OUT19/8530

**West Nowra landfill Expansion (SSD-7187) (Shoalhaven City)
EIS Exhibition**

Figure 5 Hydraulic Head Surfaces

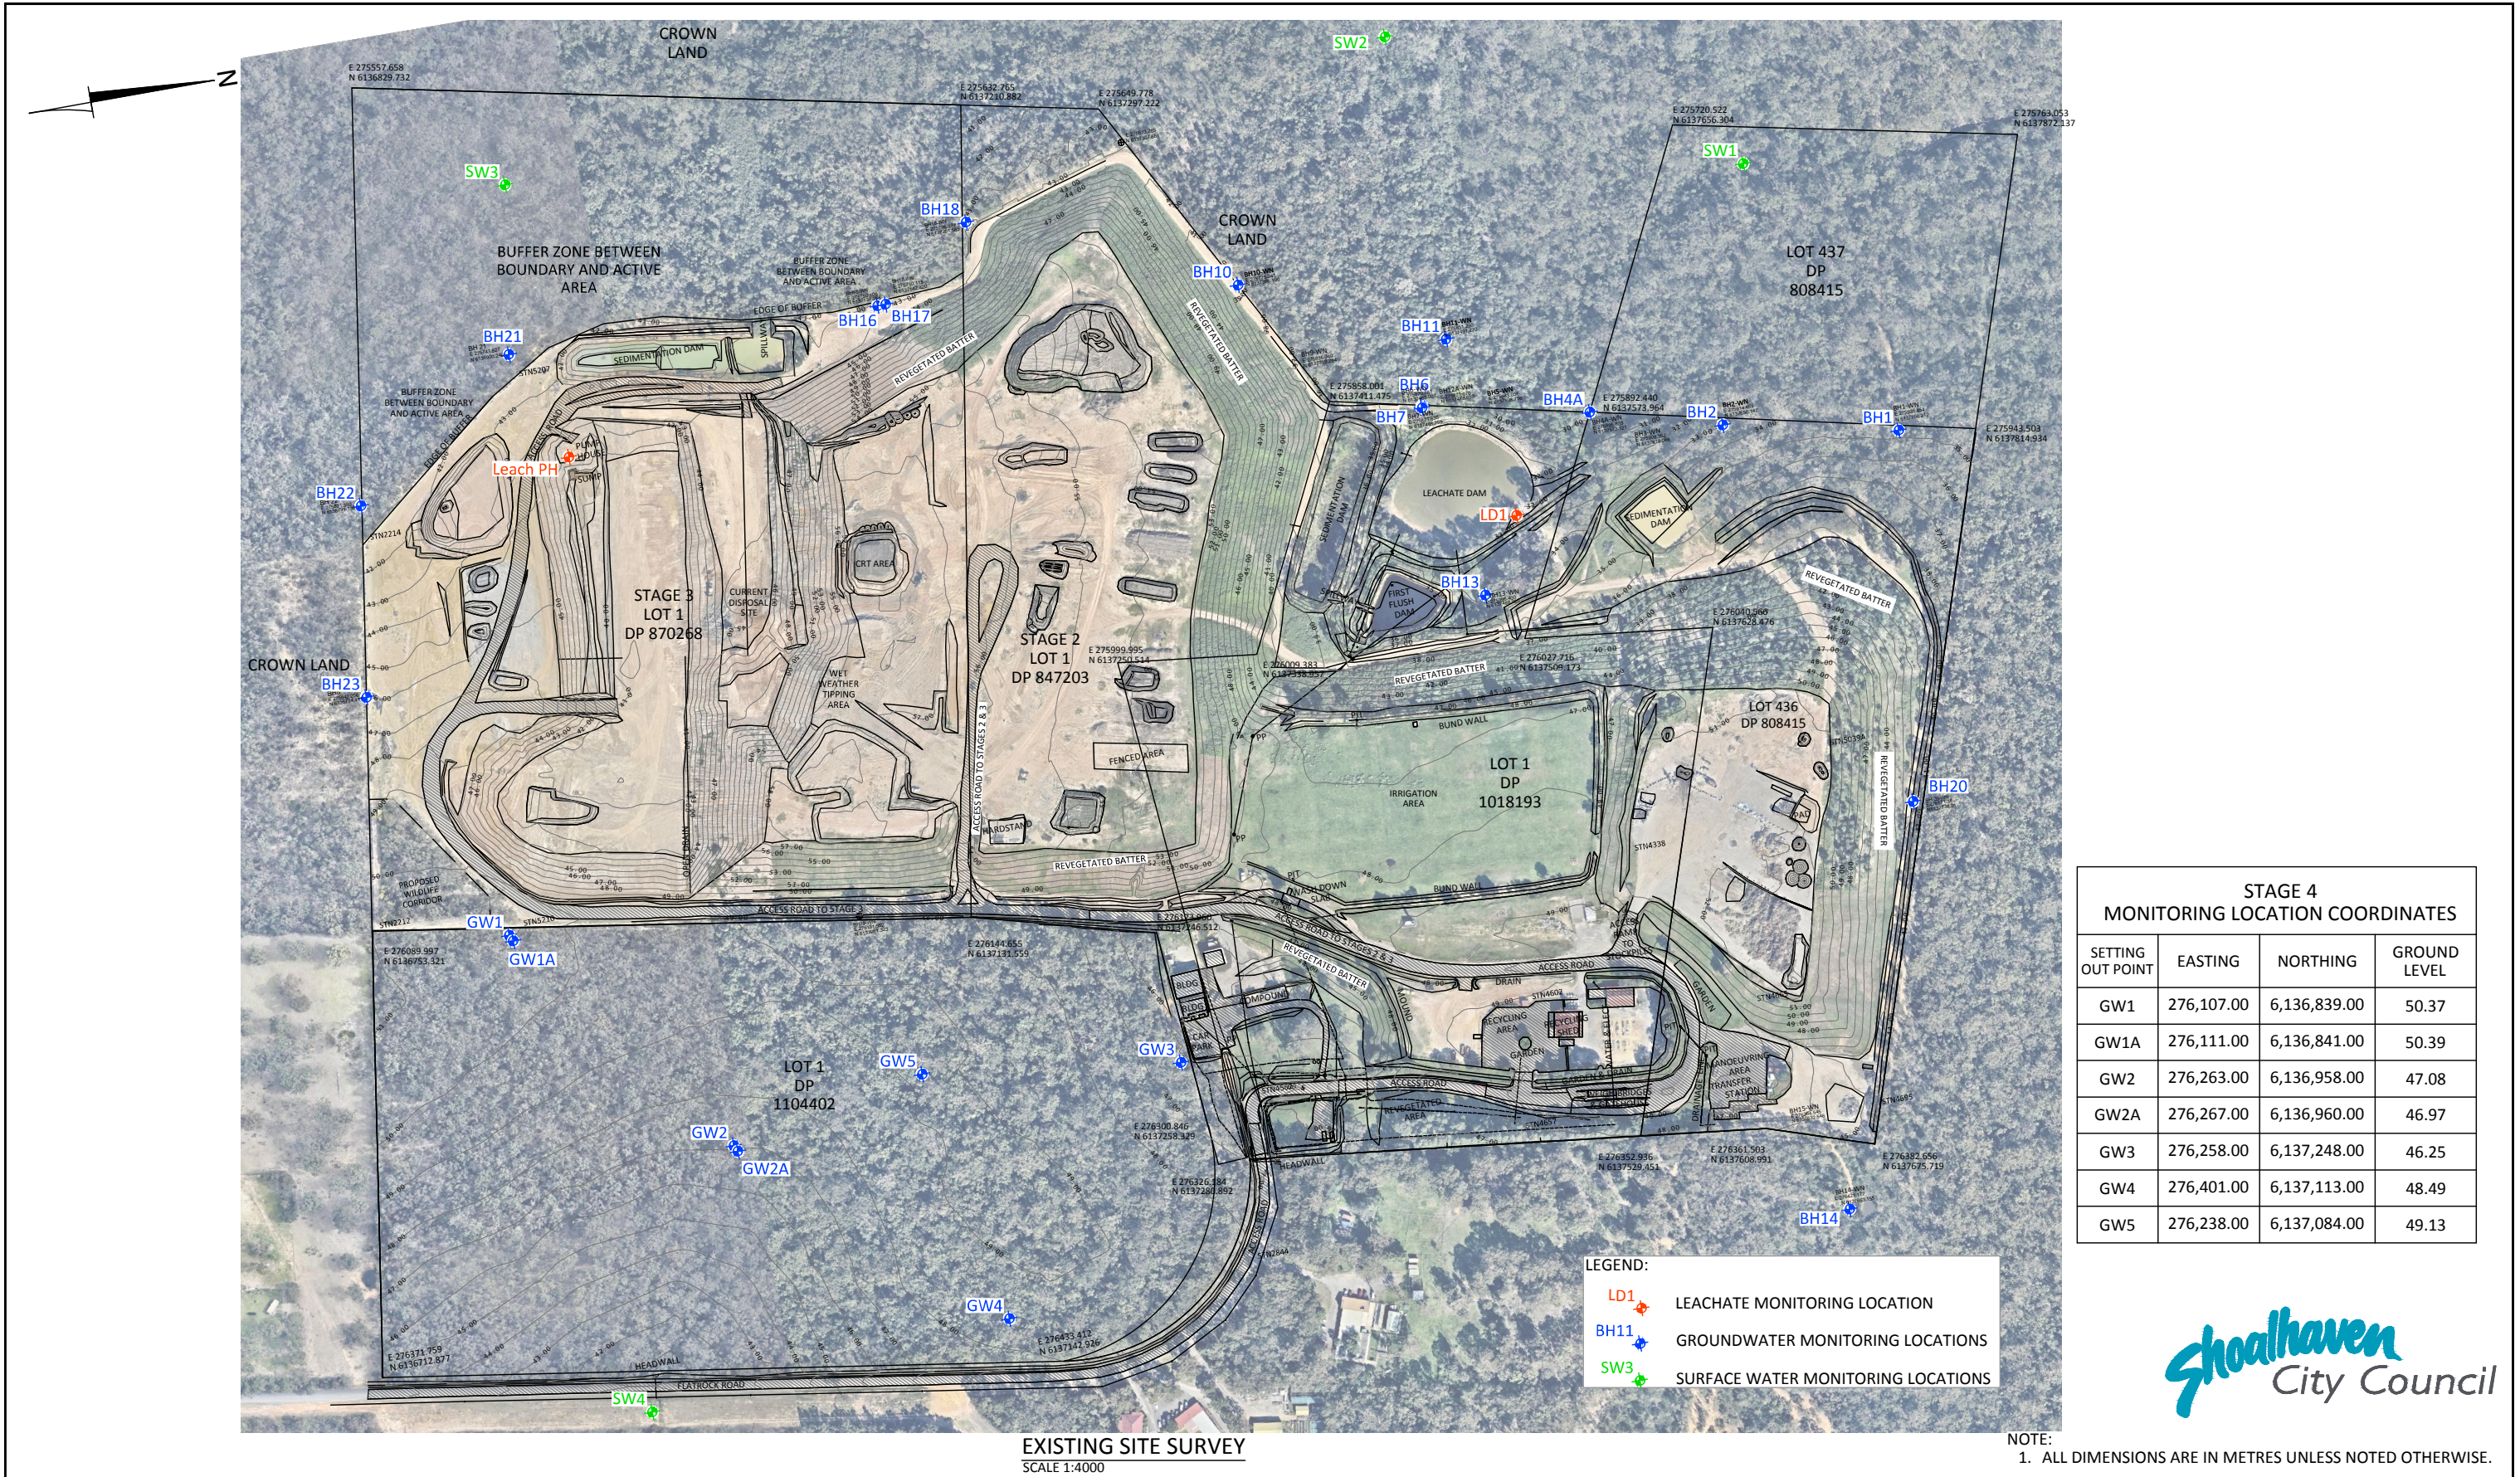
- The ongoing monitoring and reporting requirements should assess for the risk of hydrostatic pressure beneath the line. A contingency response plan should be developed to manage this risk should groundwater levels rise above a nominated threshold(s).
